## **OXFORDSHIRE COUNTY COUNCIL'S RESPONSE TO CONSULTATION ON THE FOLLOWING DEVELOPMENT PROPOSAL**

**Application no:** 14/00002/SCOP

**Proposal:** SCOPING OPINION - Proposed development comprising up to 4,000 residential dwellings, district centre and business centre, primary and secondary schools, renewable energy park, heritage and visitor facilities, linear park, community open space, sports and recreation, landscaping and associated utilities and infrastructure

**Location:** Heyford Park Camp Road Upper Heyford Bicester OX25 5HA

FIGURE 3

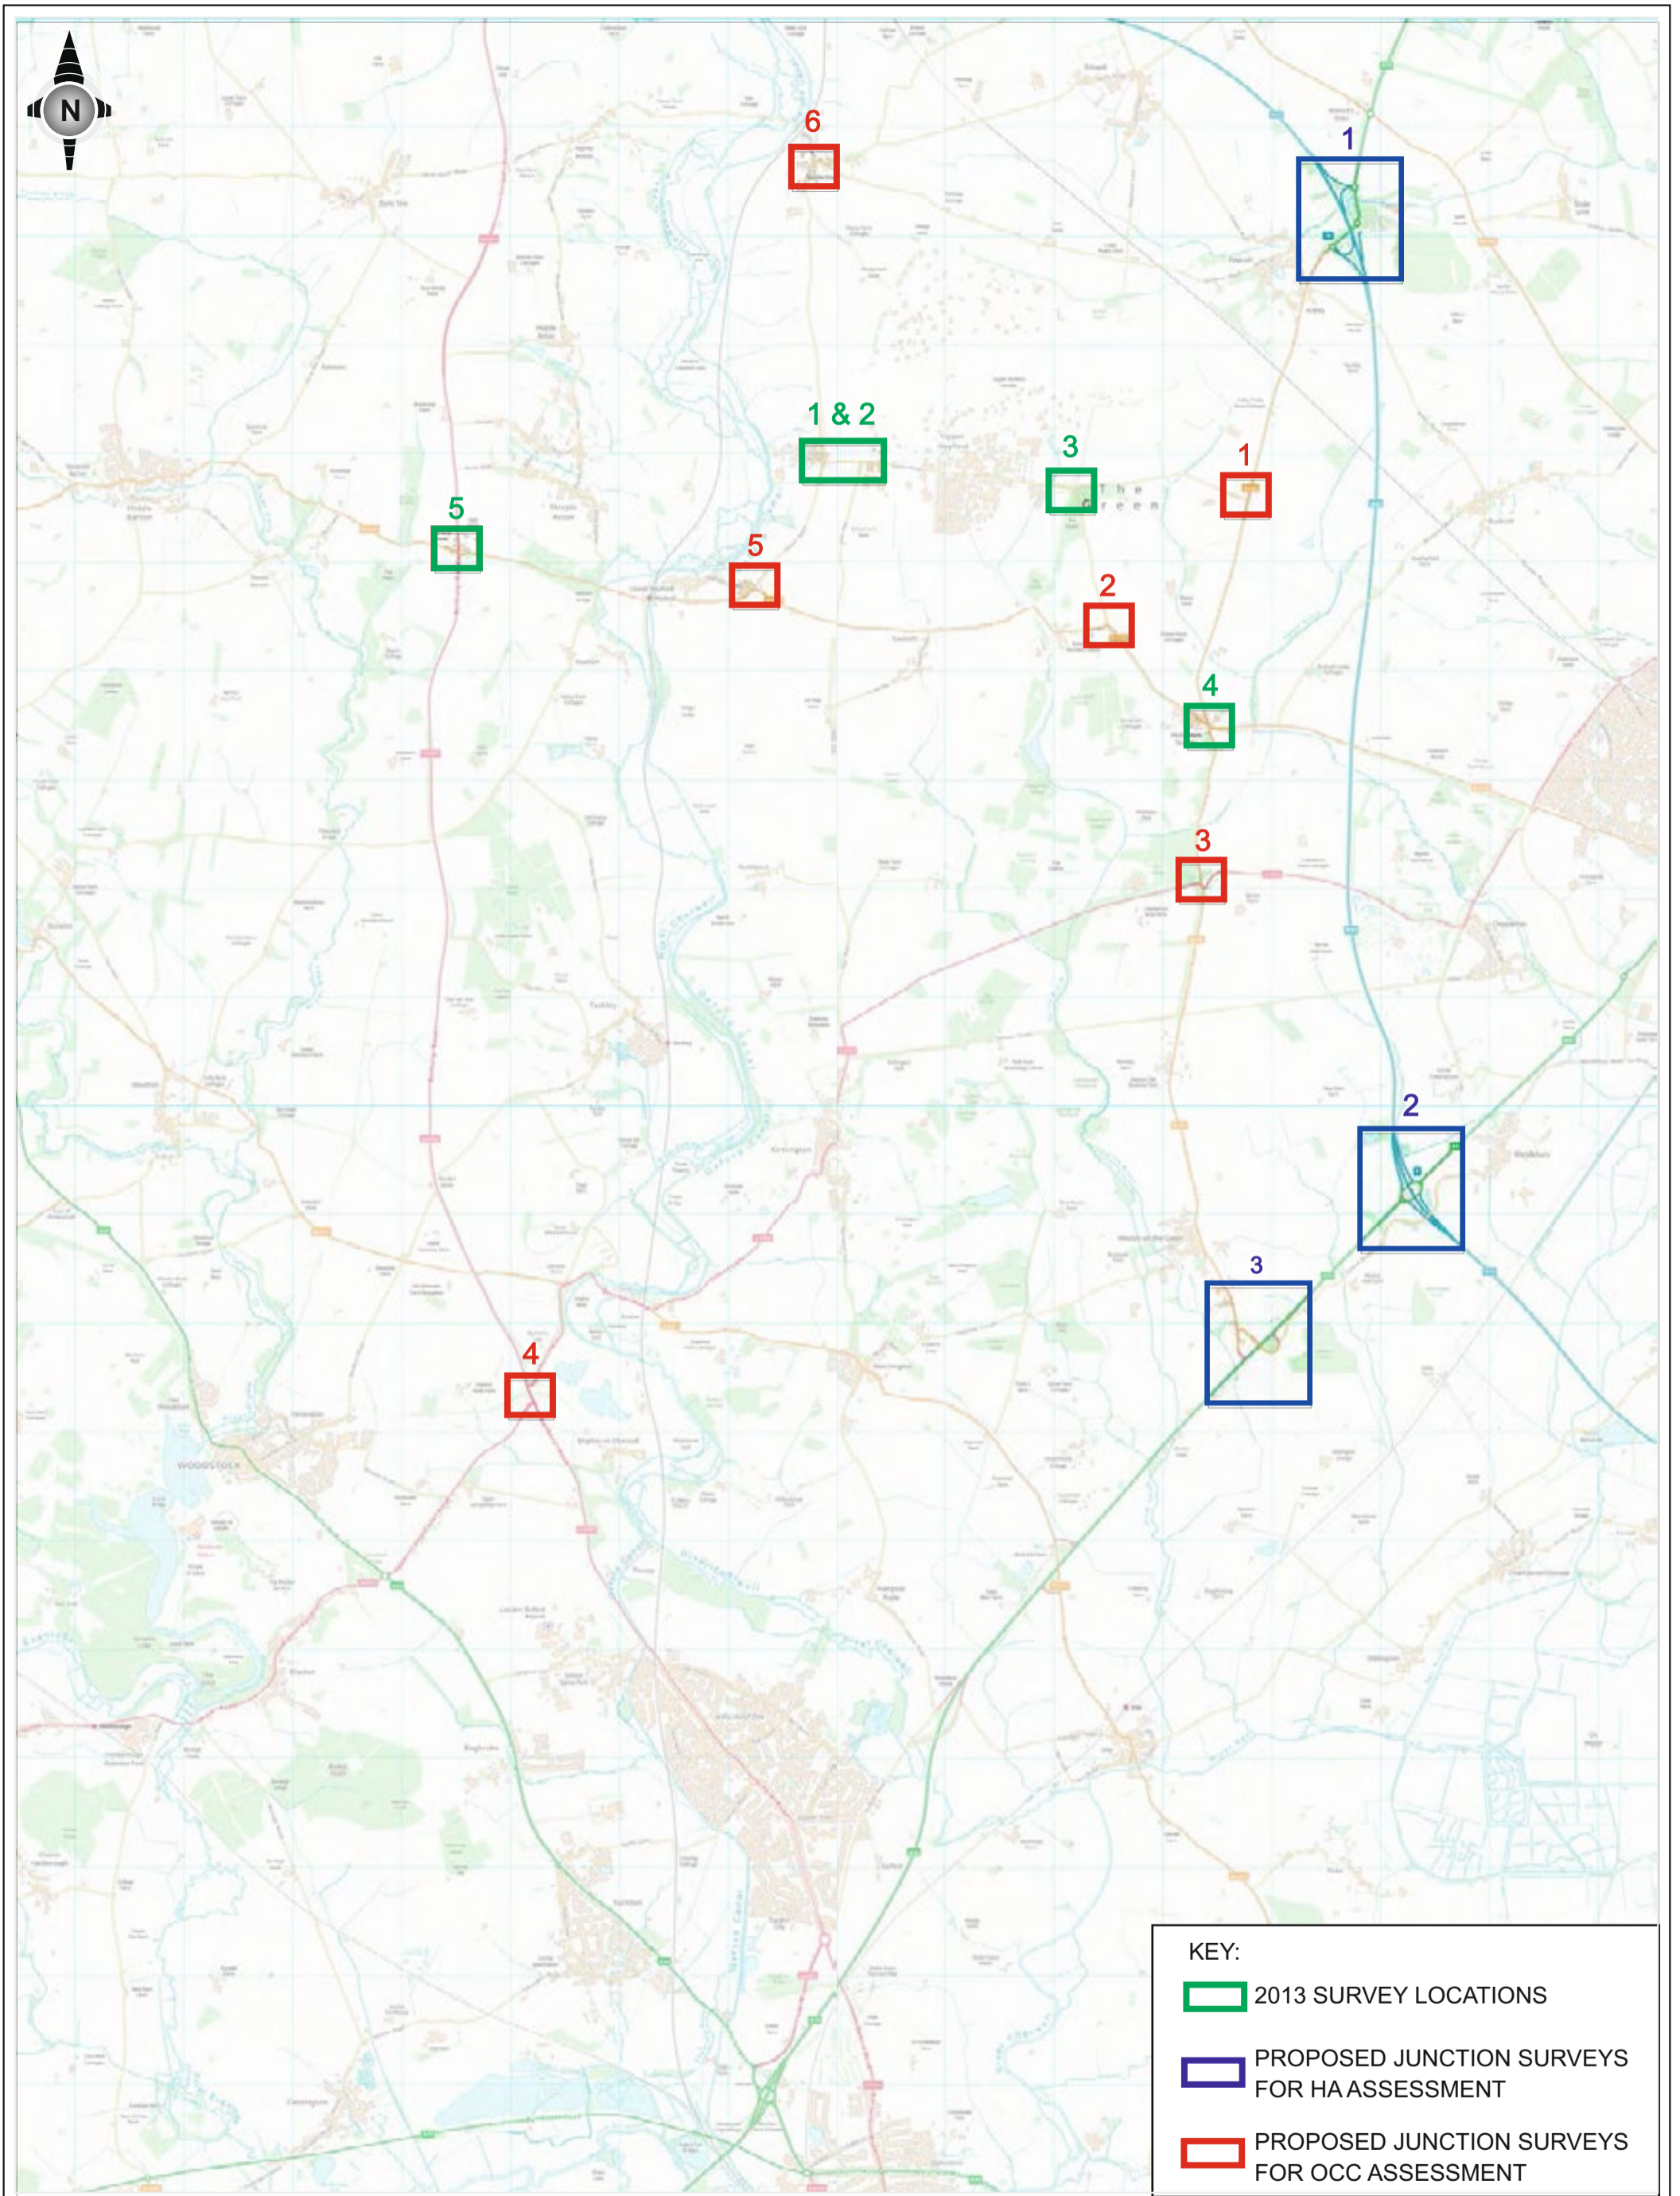
- 3.6.1 - The proposed study area is not clearly identified. Figure 3 in the appendix indicates certain junctions to be assessed, but more may be required once strategic modelling work is carried out. For clarity the extent of the entire study area including routes is required. With known committed developments in the Bicester area and the likely impact of this proposal, the study area may well need to extend to junctions in and around Bicester.
